29 January 2025

Jessica Watson
Senior Environmental Assessment Officer
Department of Planning, Housing and Infrastructure

State Significant Development - Pottinger Wind Farm - Major Project reference: SSD-59235464

09E - Broken Hill Bypass Option 3
 Strategic Design
 Pottinger Wind Farm

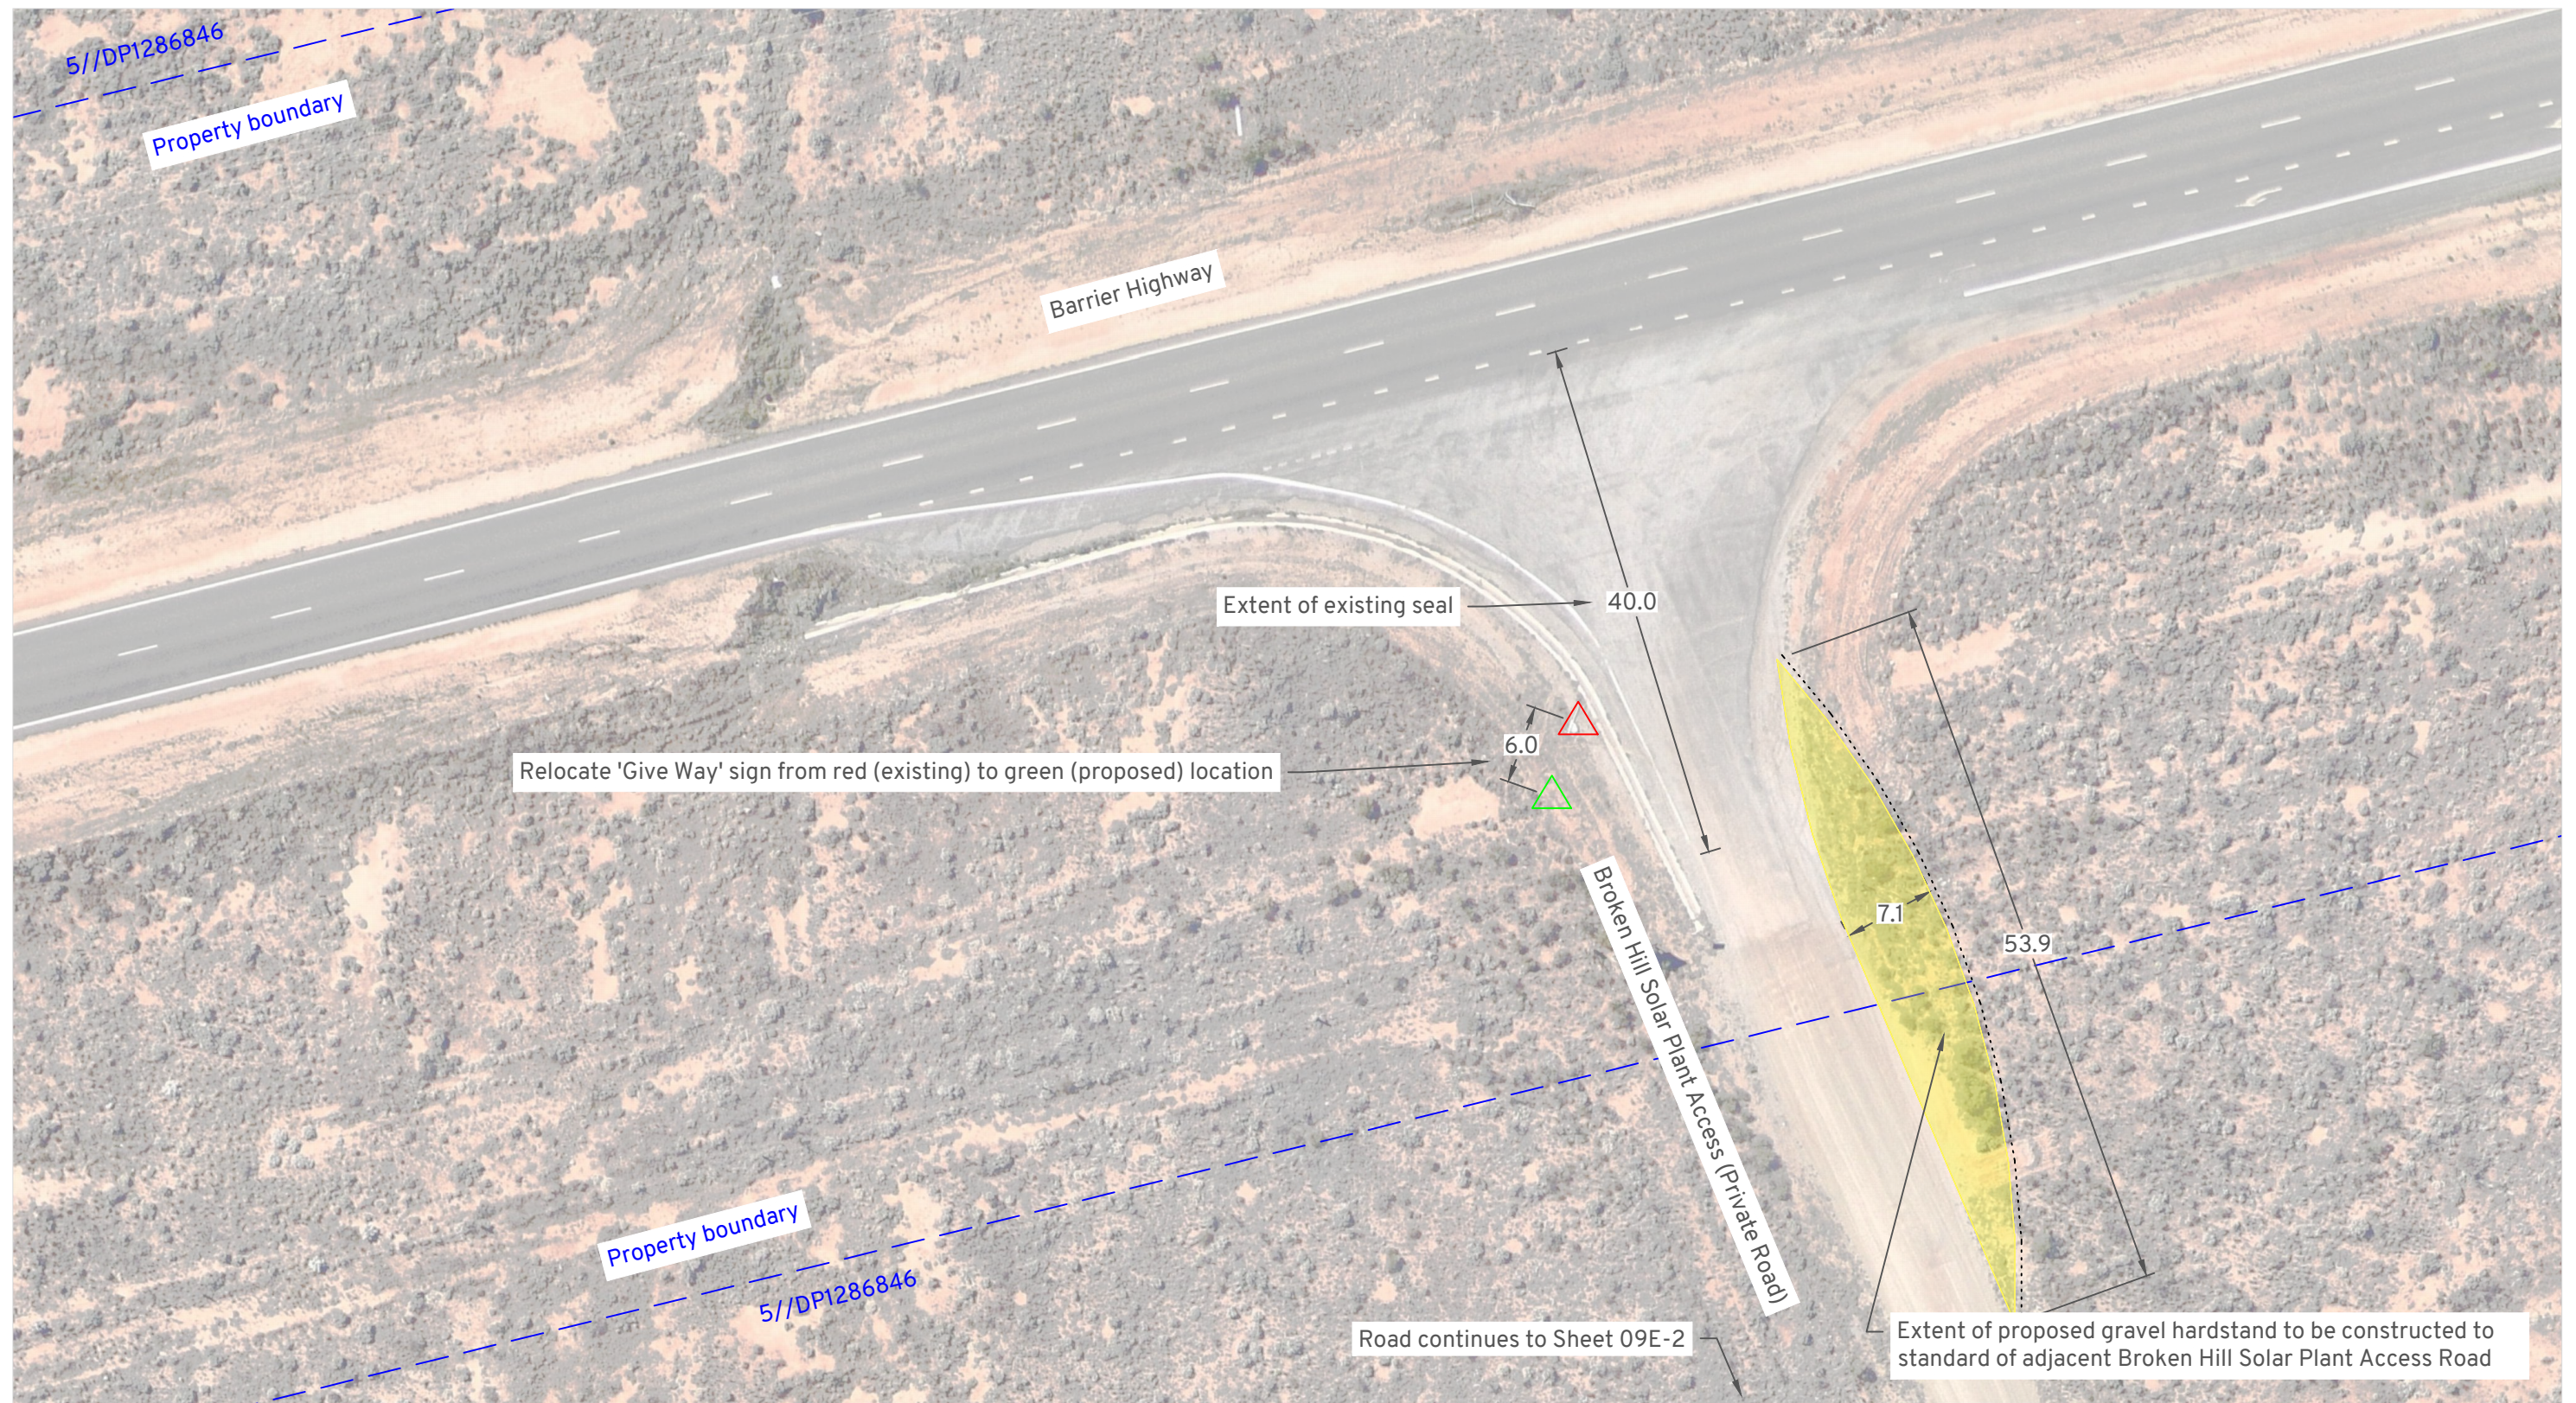
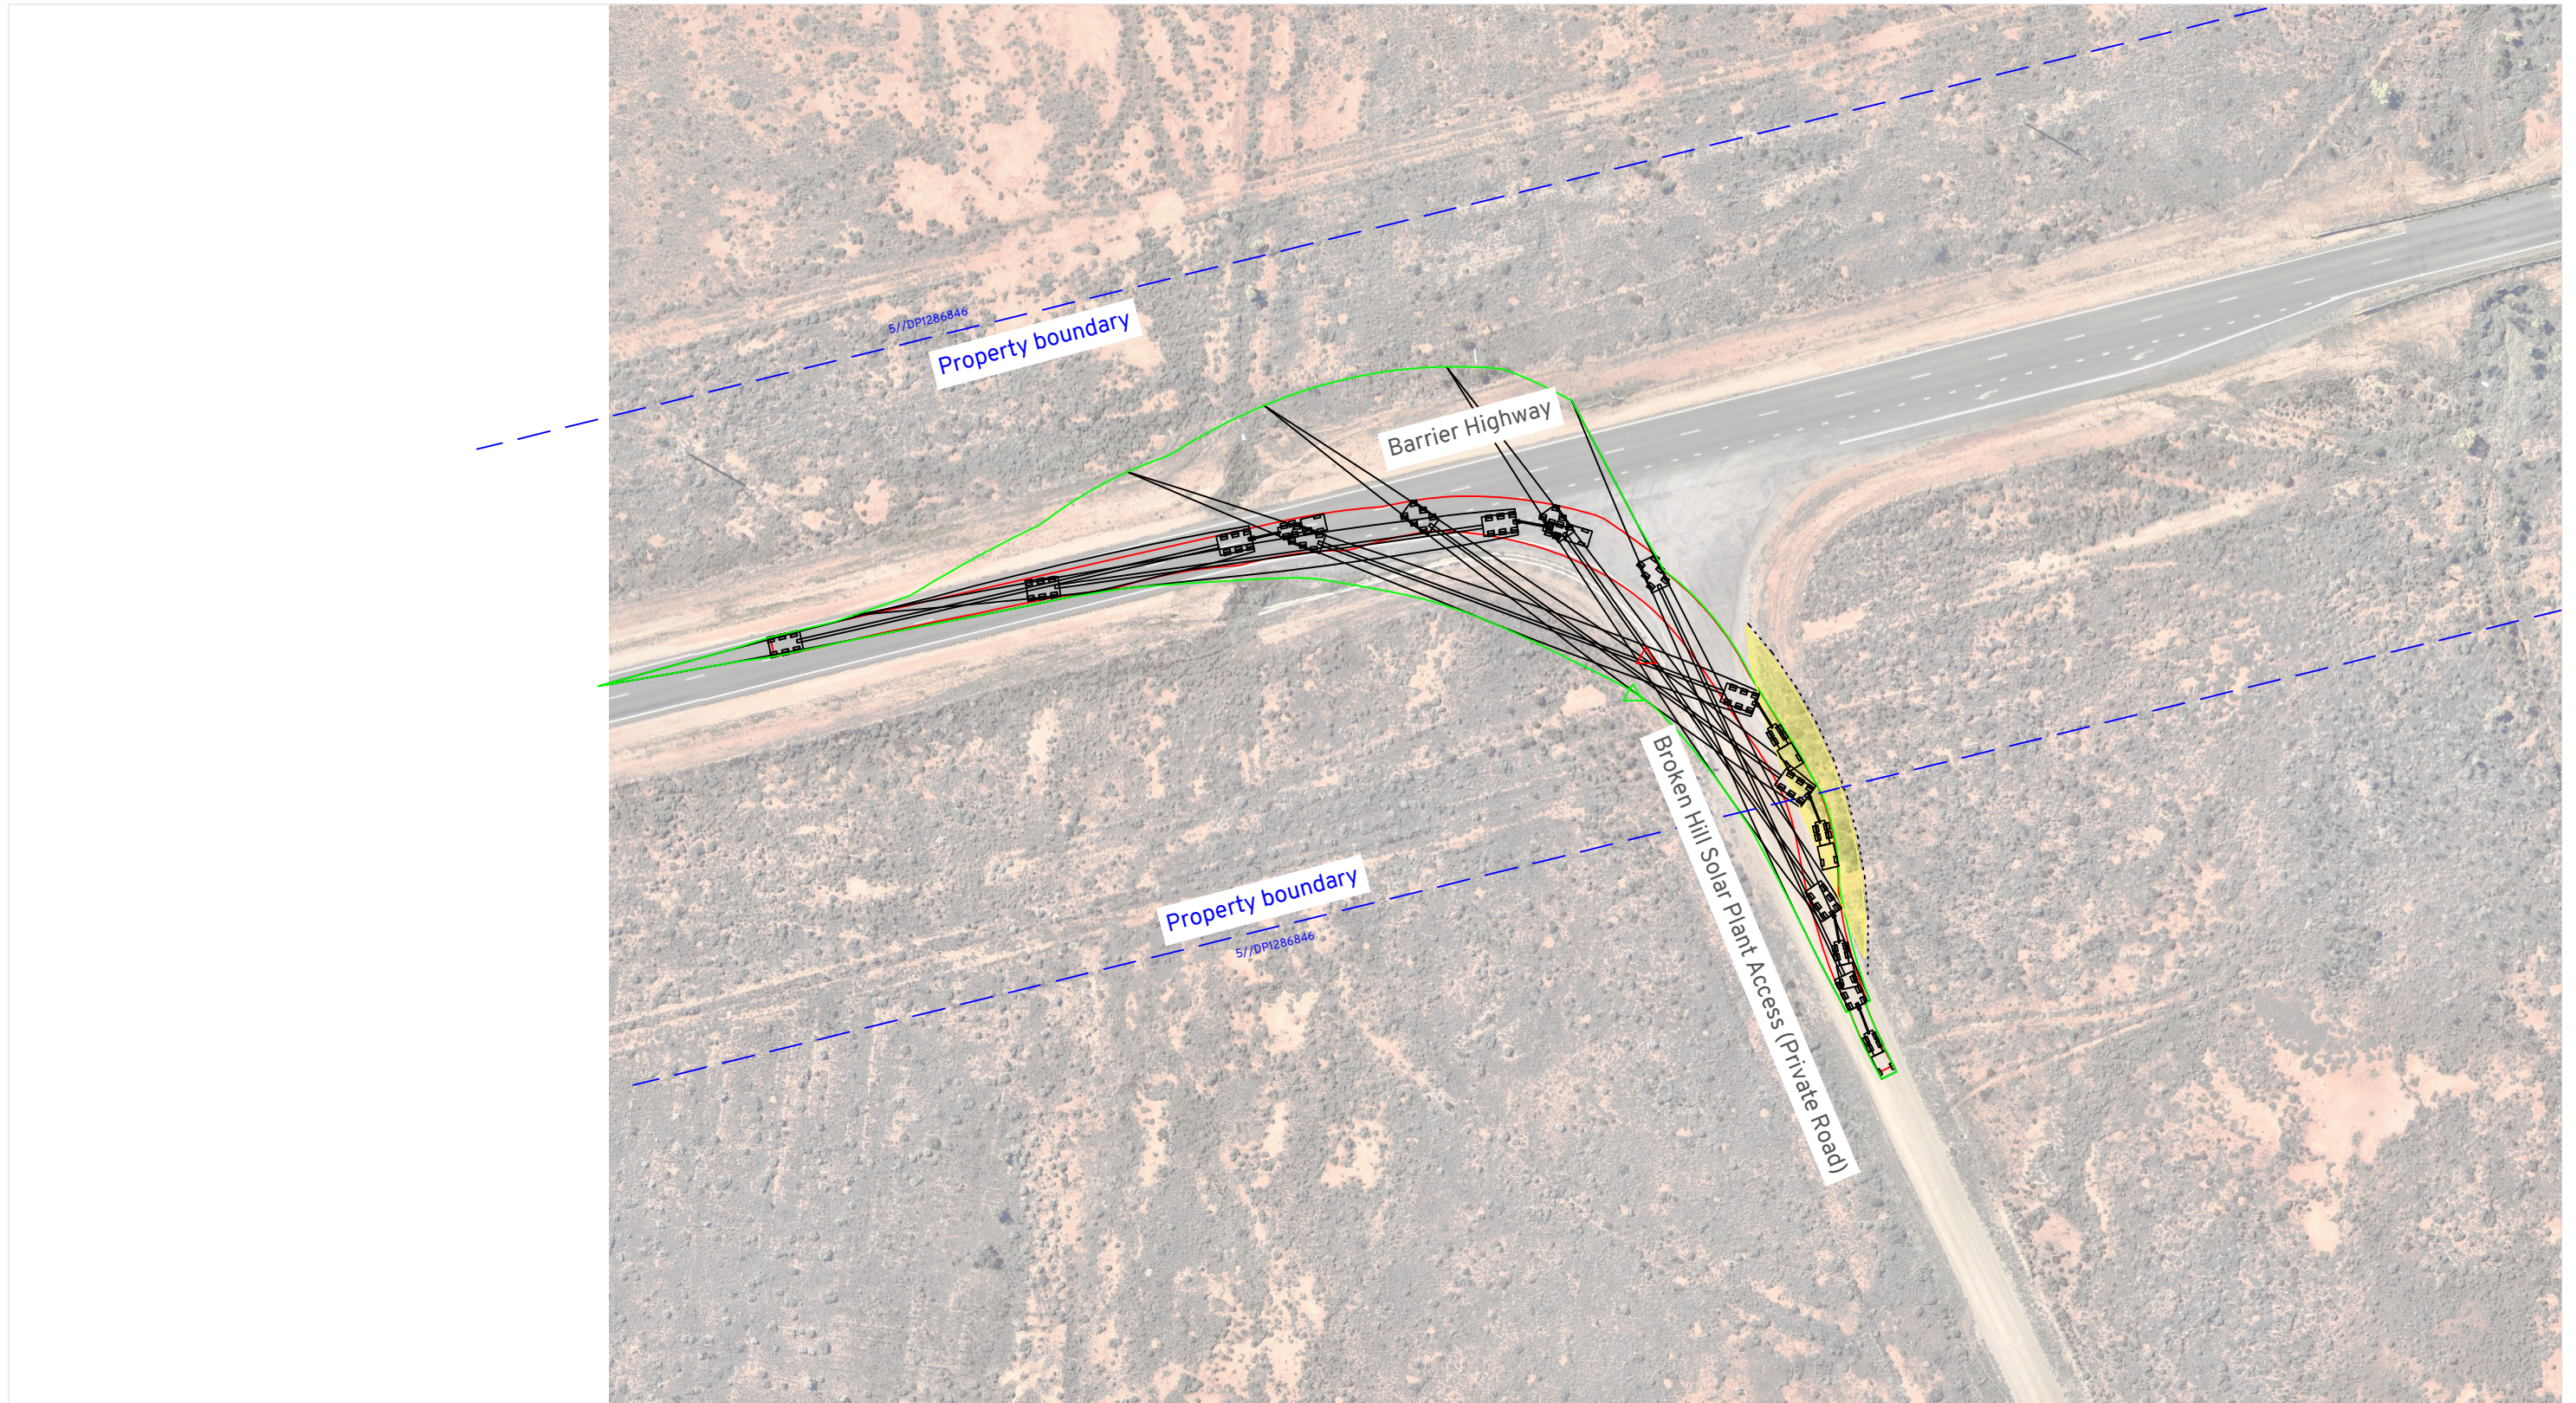
- Council requests clarification be provided by the proponent as to whether the temporary bypass from the Barrier Highway in the Broken Hill LGA, is to be removed.
